Trent Valley Internal Drainage Board

1st December 2025

One Earth Solar Farm request for information -Trent Valley IDB assets

Appendix B Example Trenchless Crossing Cross-Sections

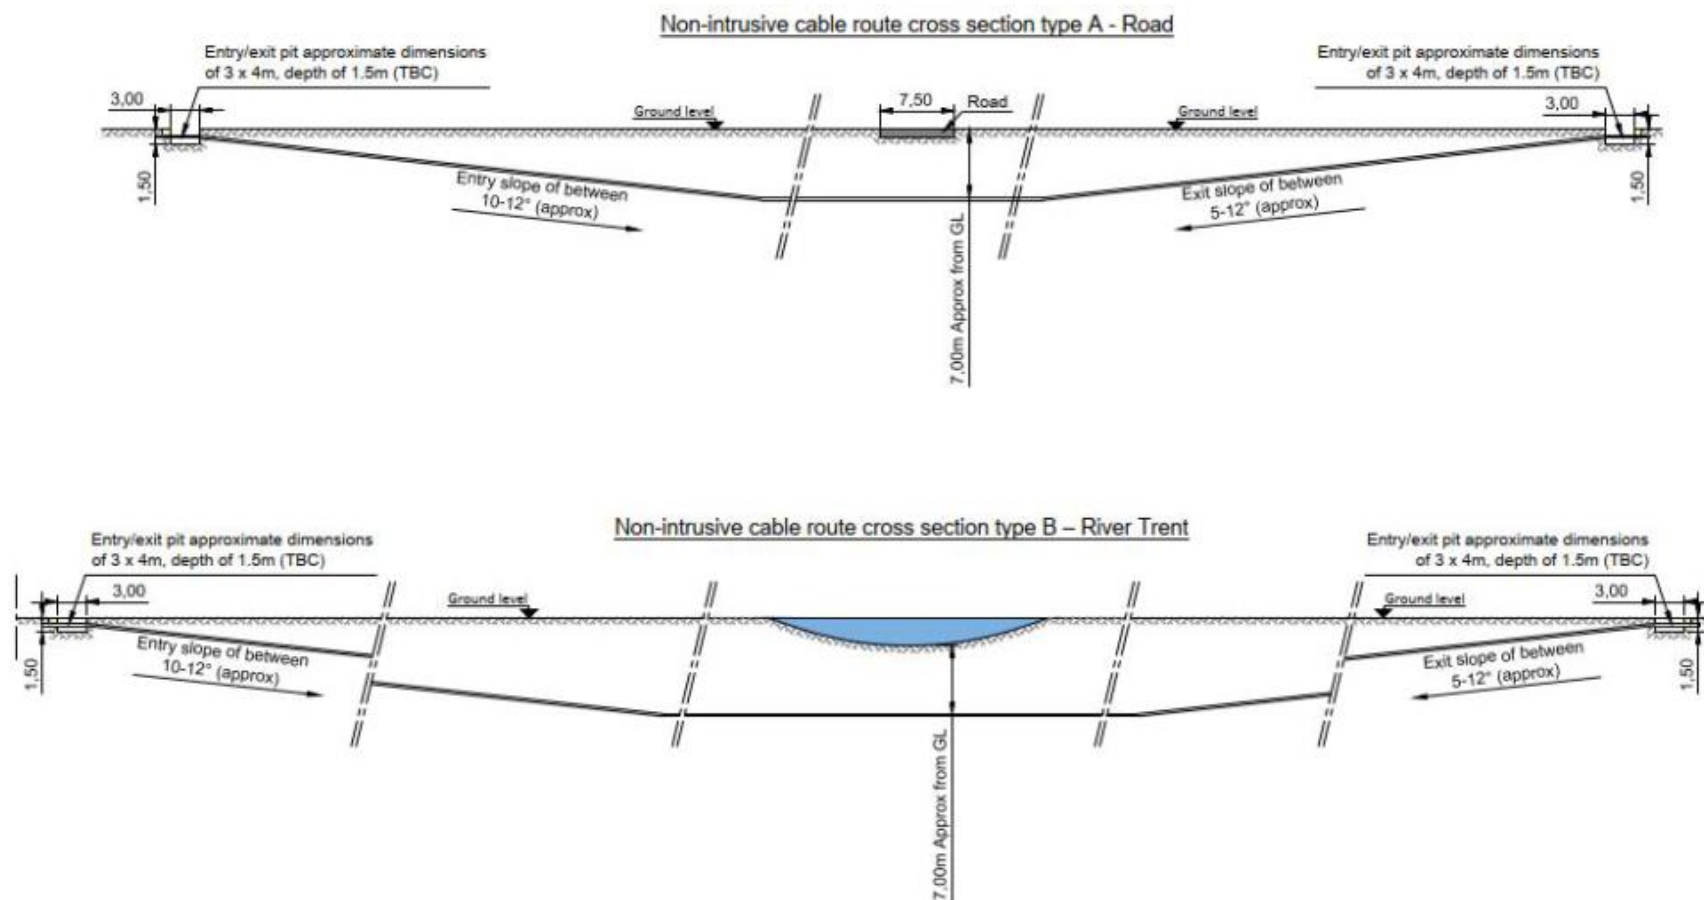
The Board will require all watercourses to be crossed by means of HDD (or other suitable trenchless technology) at a depth no less than 2 metres PLUS the cable safety distance below the hard bed level of all watercourses (to ODN if EA or IDB maintained). This will allow the IDBs to have the flexibility to improve watercourses in the future due to climate change (works will include deepening & widening of watercourses).
